# BENT GRASS EAST COMMERCIAL FILING NO. 3

## CONSTRUCTION DRAWINGS

APRIL 2021

**BENT GRASS MEADOWS DRIVE
(STRIPING IMPROVEMENT PLAN)**

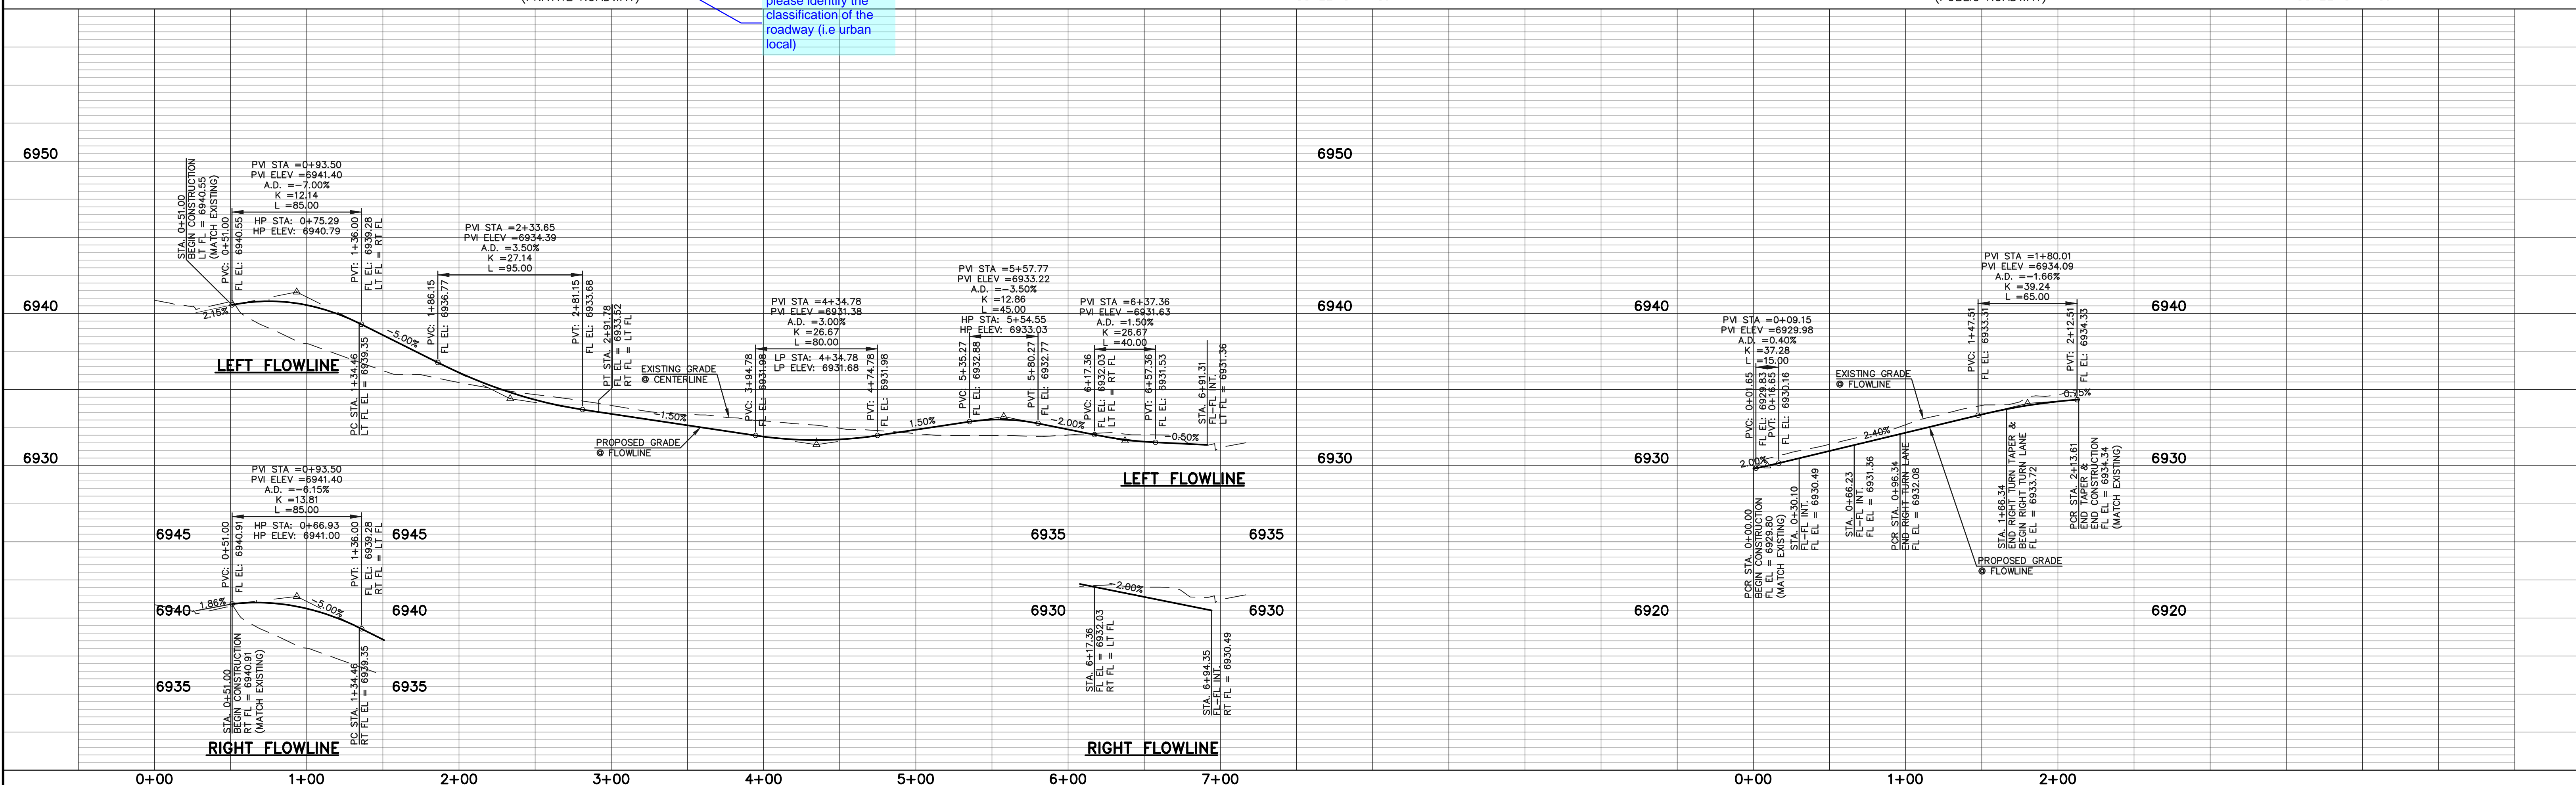
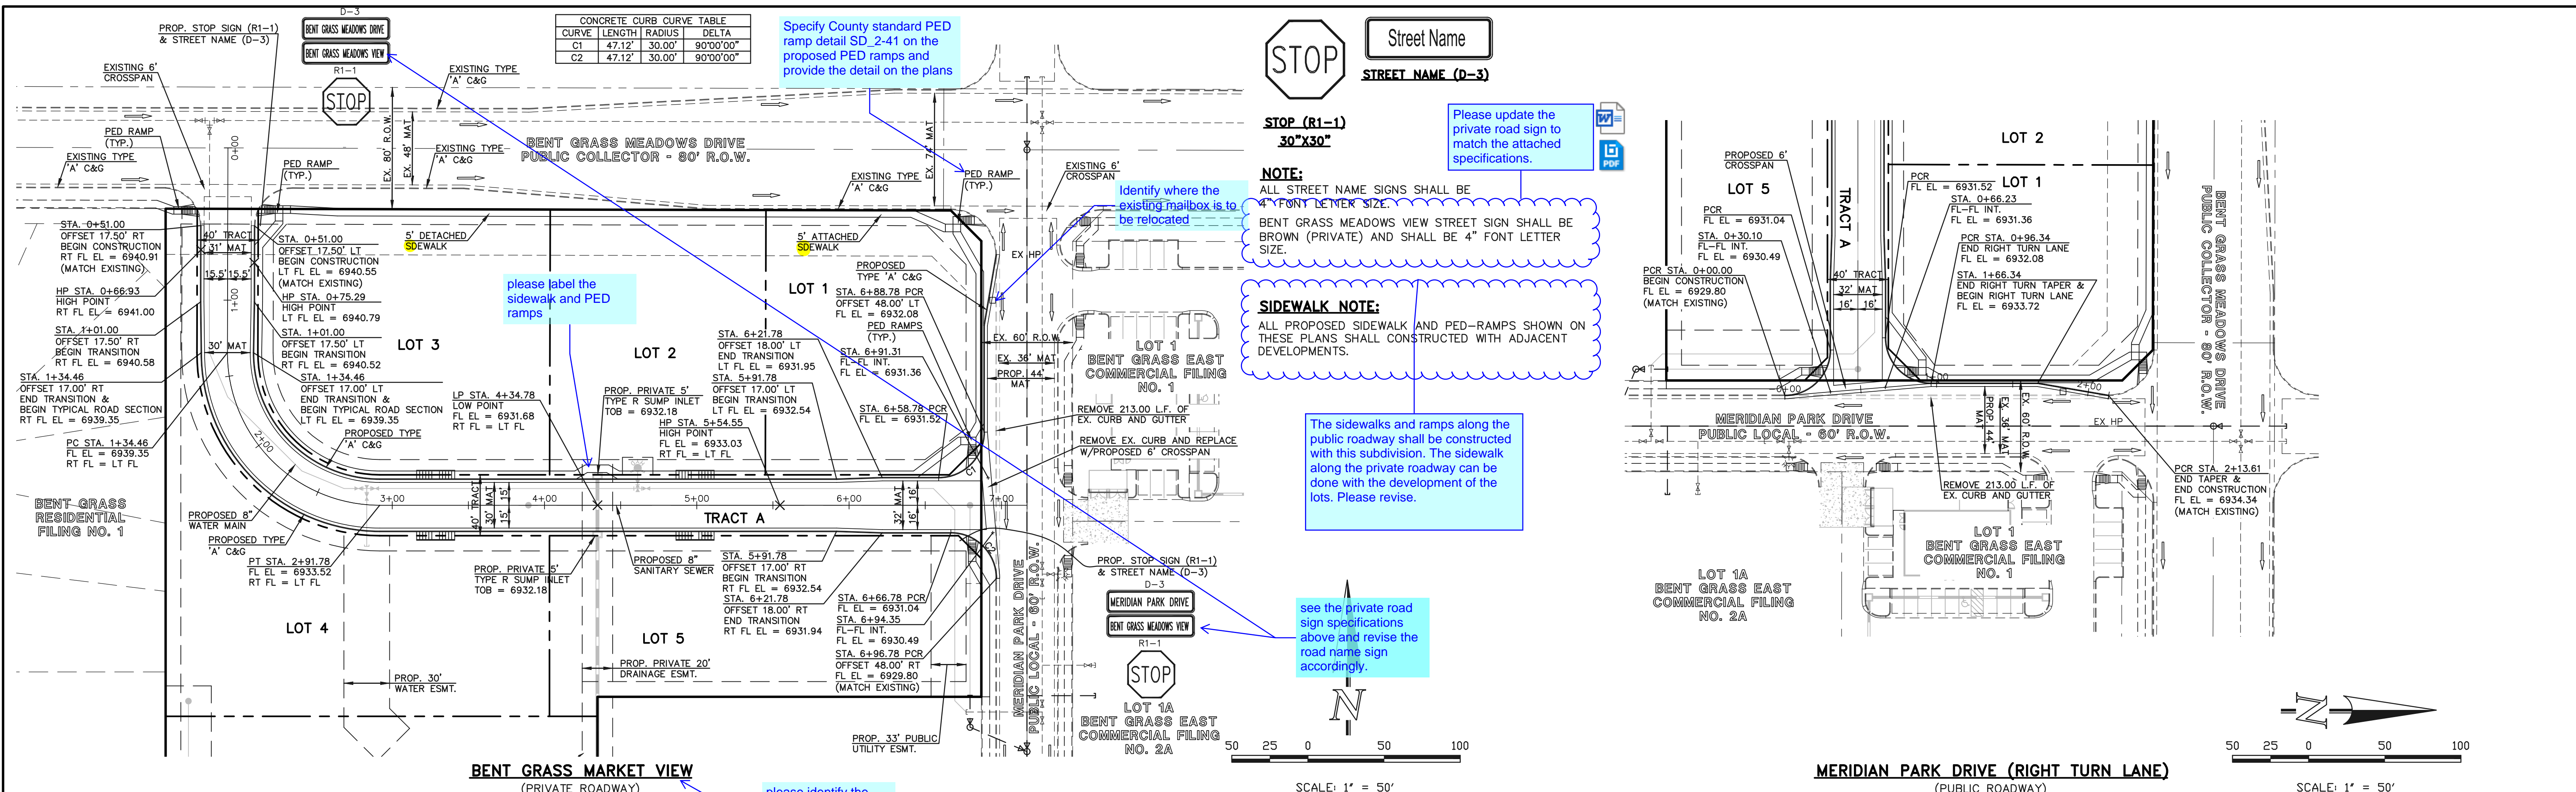
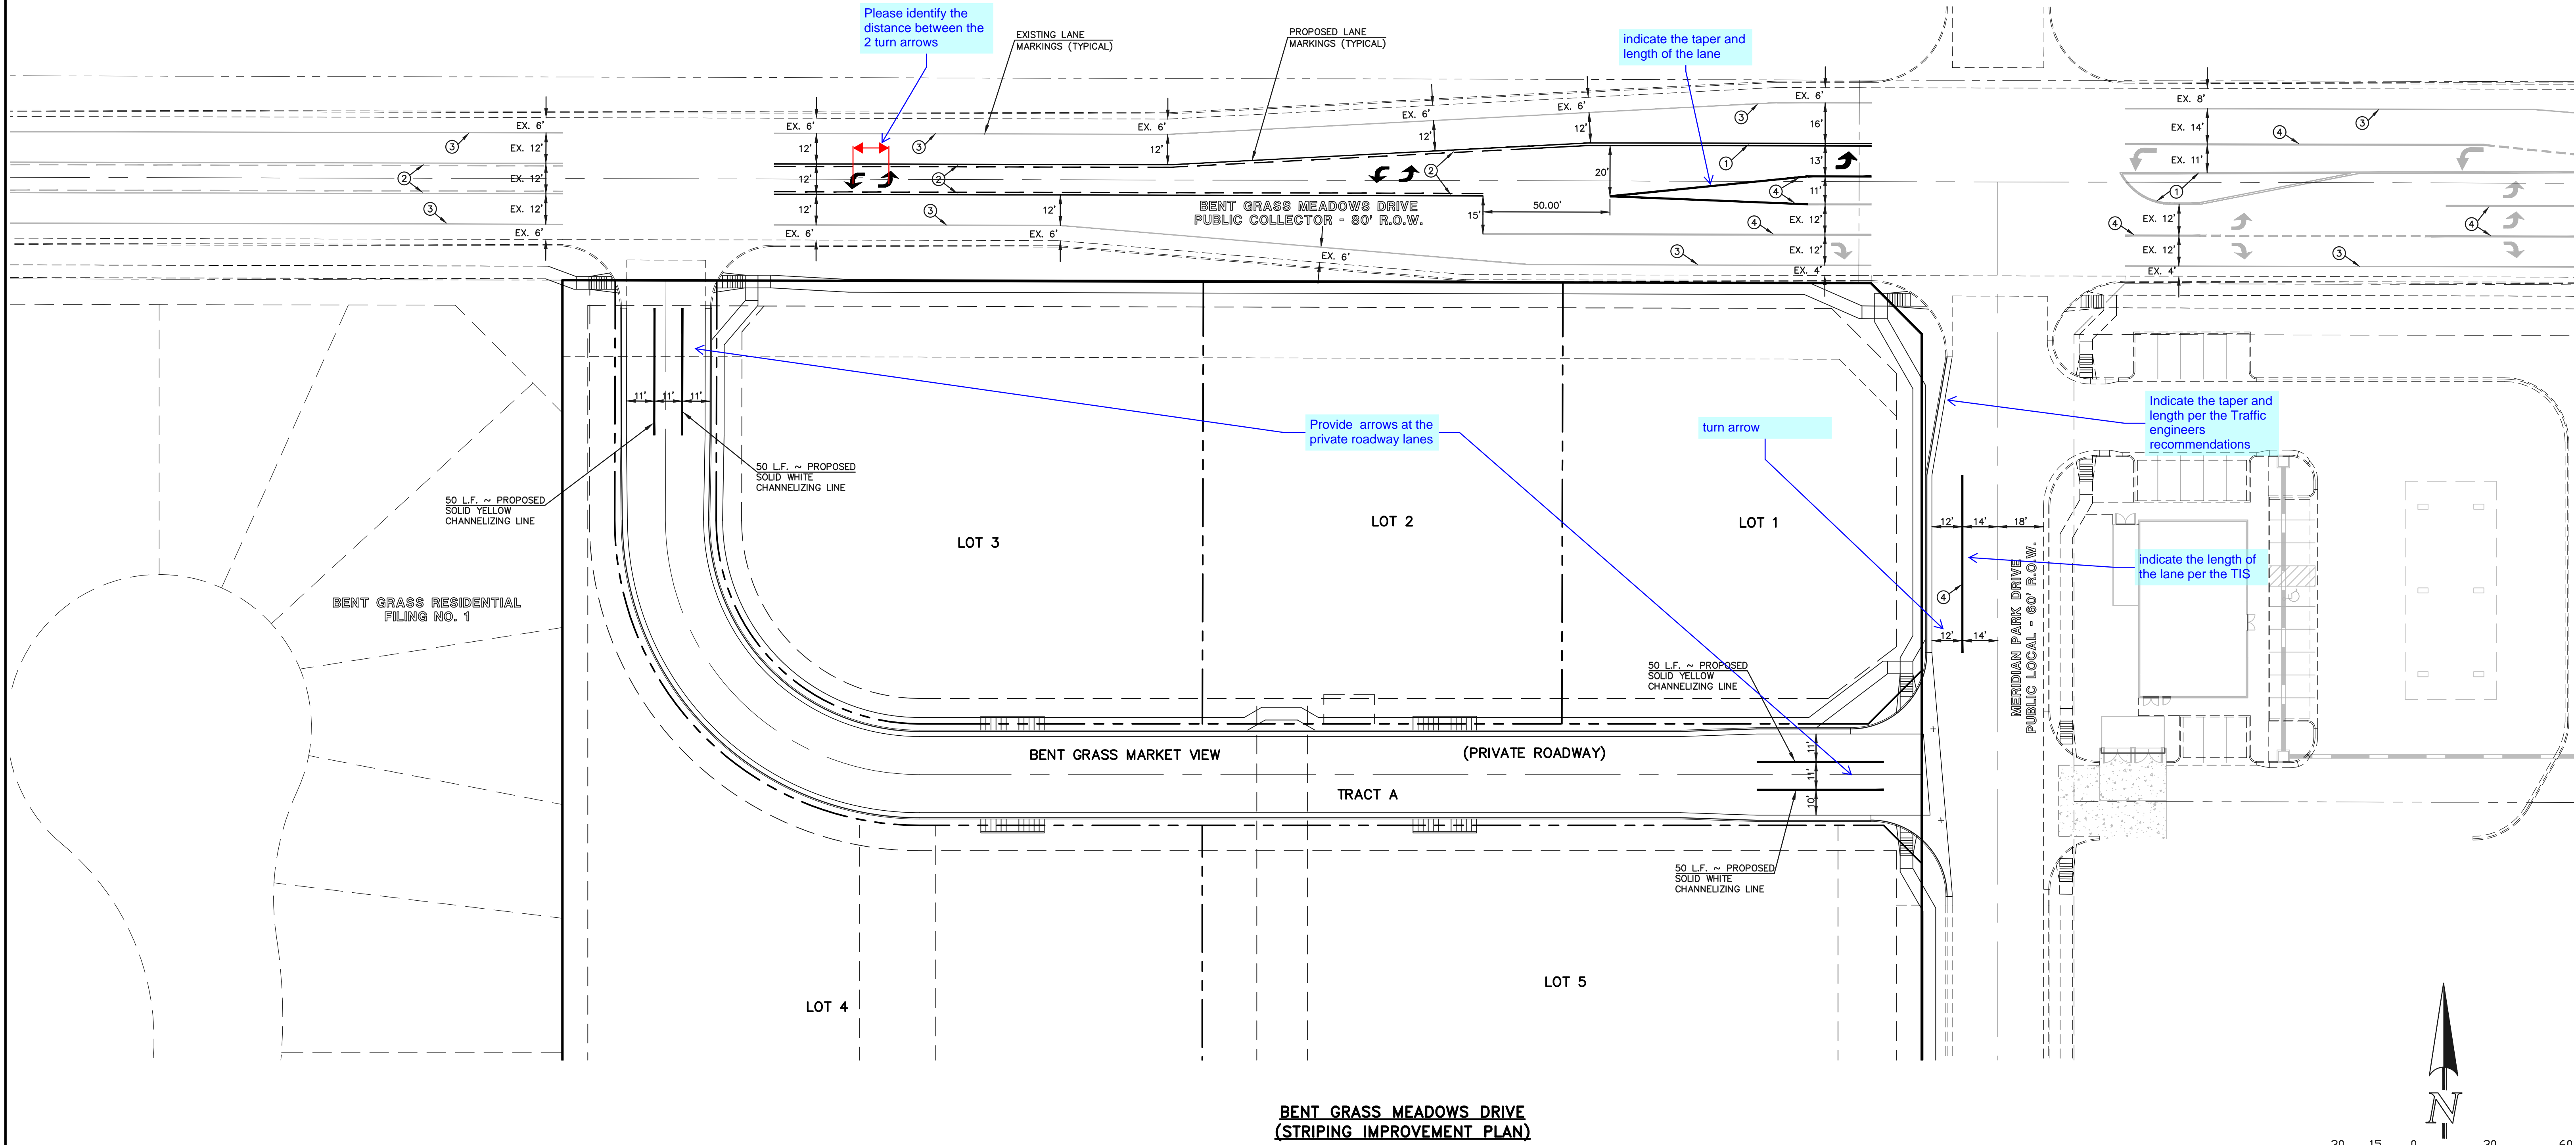
per County standard  
notes turn arrows  
shall be 125 mil.  
Please revise

Shall be 4" apart per  
CDOT standards  
(S-627-1)

REVISED

REVISED
